From: Martyn White <Martyn.White@arun.gov.uk> **On Behalf Of** Conservation Officer
Sent: 21 March 2025 17:06
To: Planning.Responses <Planning.Responses@arun.gov.uk>
Subject: CM/4/25/PL

CM/4/25/PL

Land to the West of Crookthorn Bryre Climping BN17 5QU

Erection of 1 No two storey dwelling (self build) (resubmission following CM/15/24/PL). This application affects the setting of listed buildings, is a Departure from the Development Plan and is in CIL Zone 5 and is CIL Liable as a new dwelling.

WEST ELEVATION AND SECTION B-B'

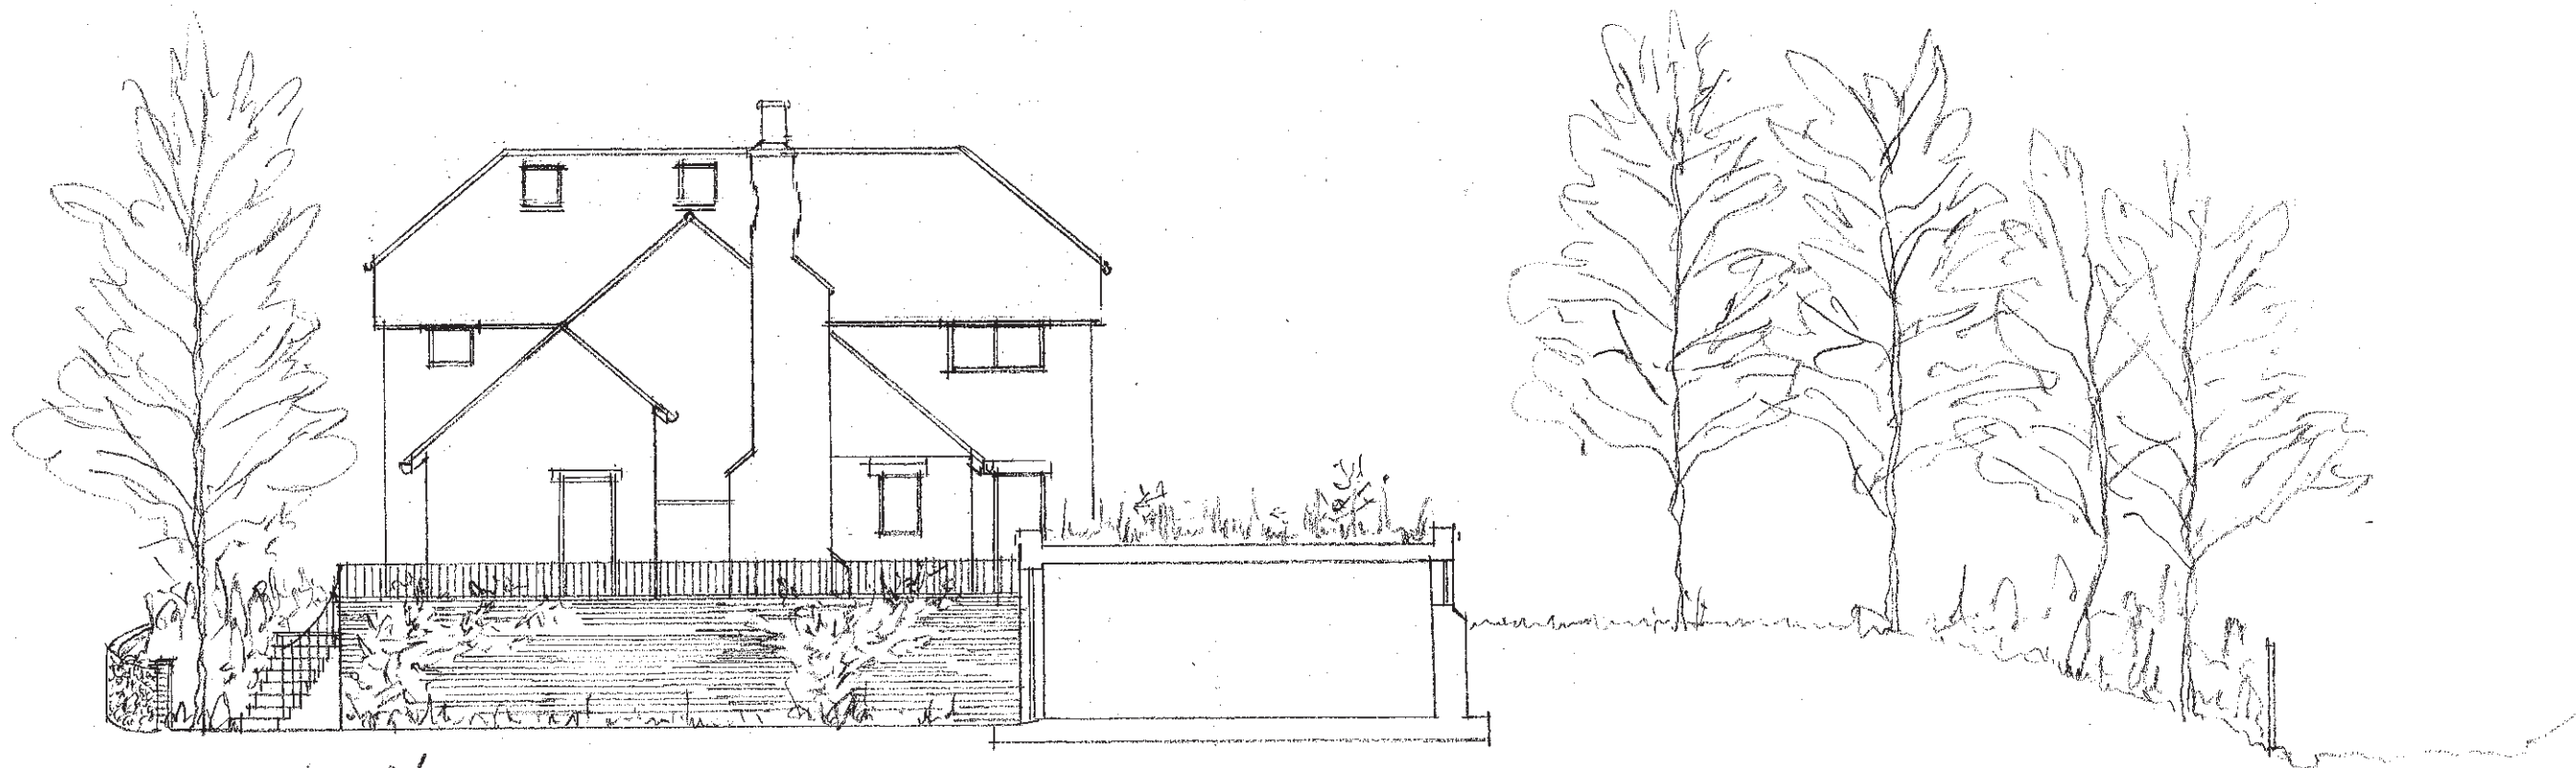
The new house would appear to be an attempt to reflect the existing rural character; It is assumed that the intention was to give the appearance of a 'barn conversion' and be built using a mixture of brick, flint and timber horizontal cladding. However, at present, based on the drawings provided, it remains unclear how the design would faithfully reflect this intention.

For instance, in order for the narrative to be successful, the design would also need to ensure that the house does not look like a new build house. As presently drawn, there are a considerable number of openings for windows and doors which remove the illusion of a barn conversion. The excessive number of solar panels also impact upon the intended narrative.

SOUTH ELEVATION AND SECTION C-C'

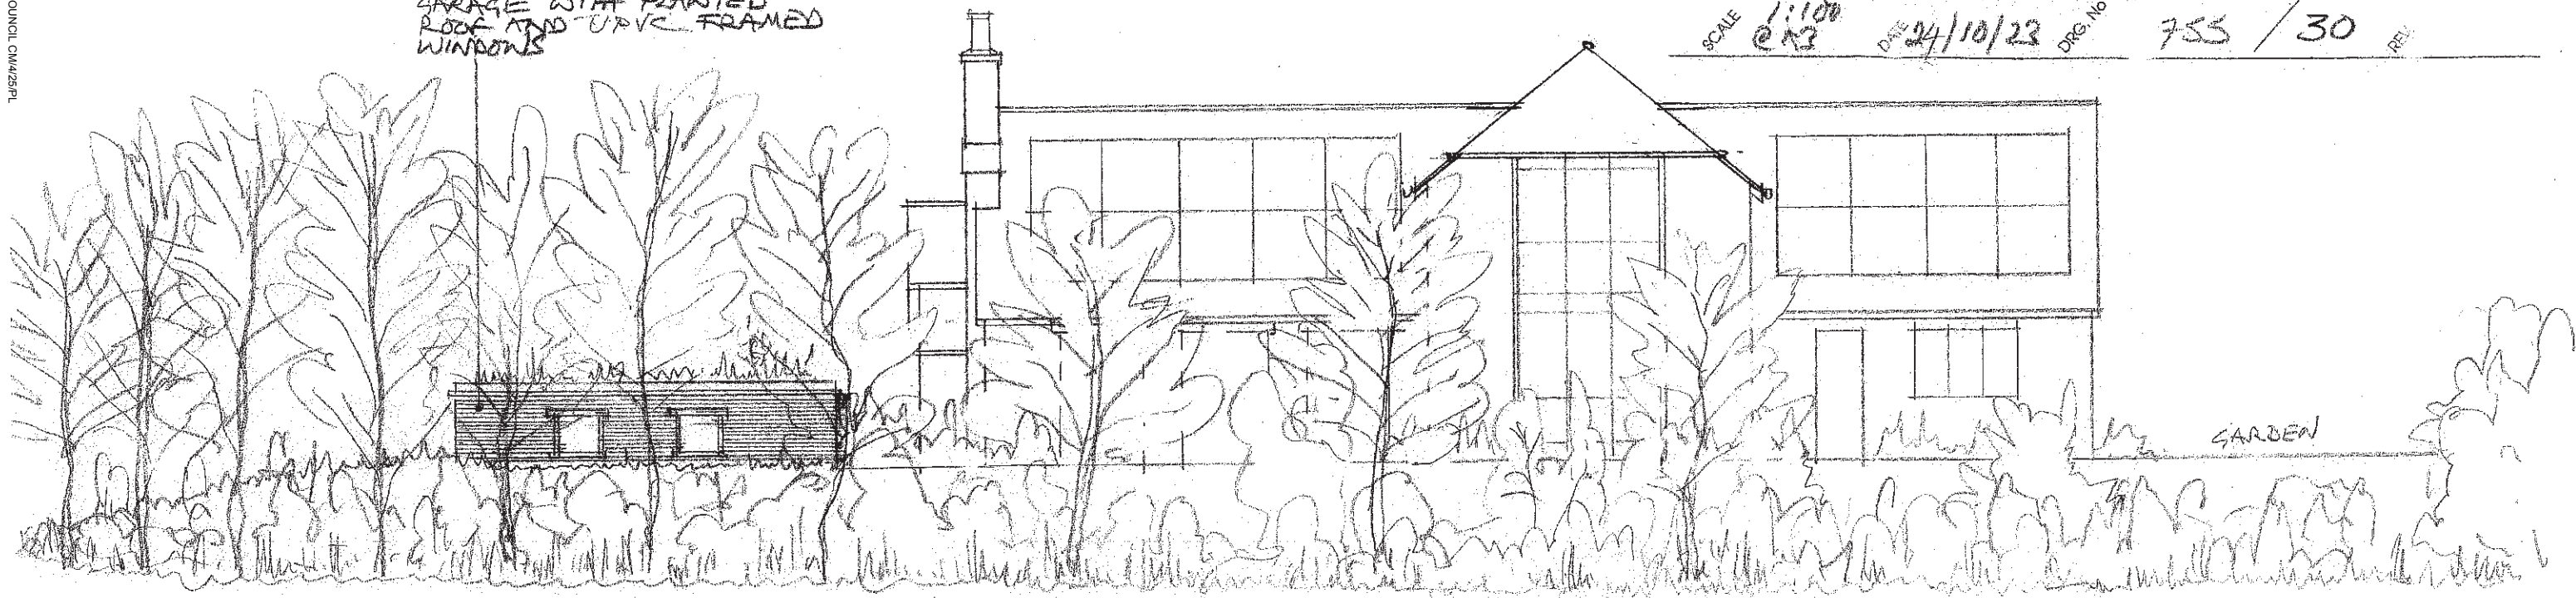
Development in such a location would clearly impact upon the established rural character of the small grouping of listed buildings. The introduction of the new house would remove the open nature of the site and replace it with a fairly large dwelling and separate garage building. This dwelling (and garage) would be clearly seen from the lane and on the approach to some of the attractive buildings. It would also be located close to two of the former barns.
